Your Ref: Planning Application R/2/14 - 1 Merton Avenue, Rustington

Objection to Planning Application R/2/14

proposed rear elevation

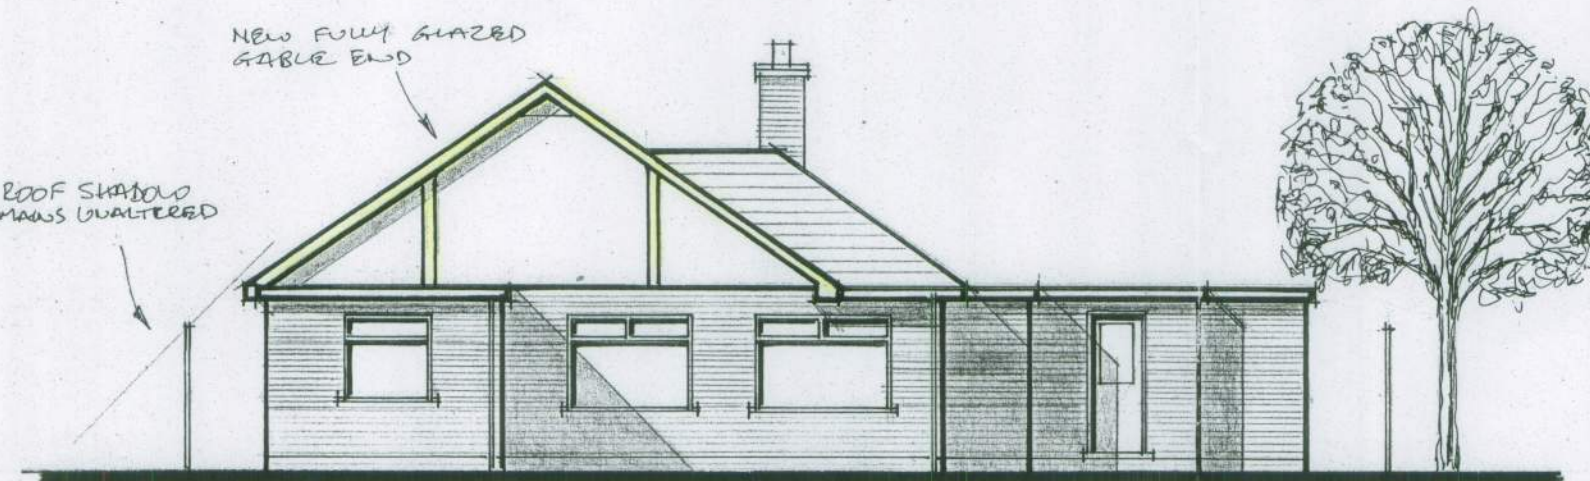
- The fully glazed gable end will overlook my garden, significantly impacting my privacy. The drawings incorrectly show "existing tree screening" on the boundary to the rear of the property adjoining my garden - these are in fact a trimmed hedge which does not provide adequate screening.

- The fully glazed gable end is not in keeping with the architecture of any nearby properties and as such would be detrimental to the housing stock of the local area. The design and scale of the rear glazing is unsympathetic and incongruous to the existing structure, plus if approved this would set an unfortunate precedent for any subsequent proposals in Rustington.

- Light pollution from the gable end would impact my property and other neighbours, thus having a significant impact on the neighbouring properties.
- The plans are incomplete - there is no drawing of the existing and proposed side elevation from the west, showing what treatment is to be made of that face of the building. This aspect of the plans could therefore not be assessed nor could they be enforced in the future.
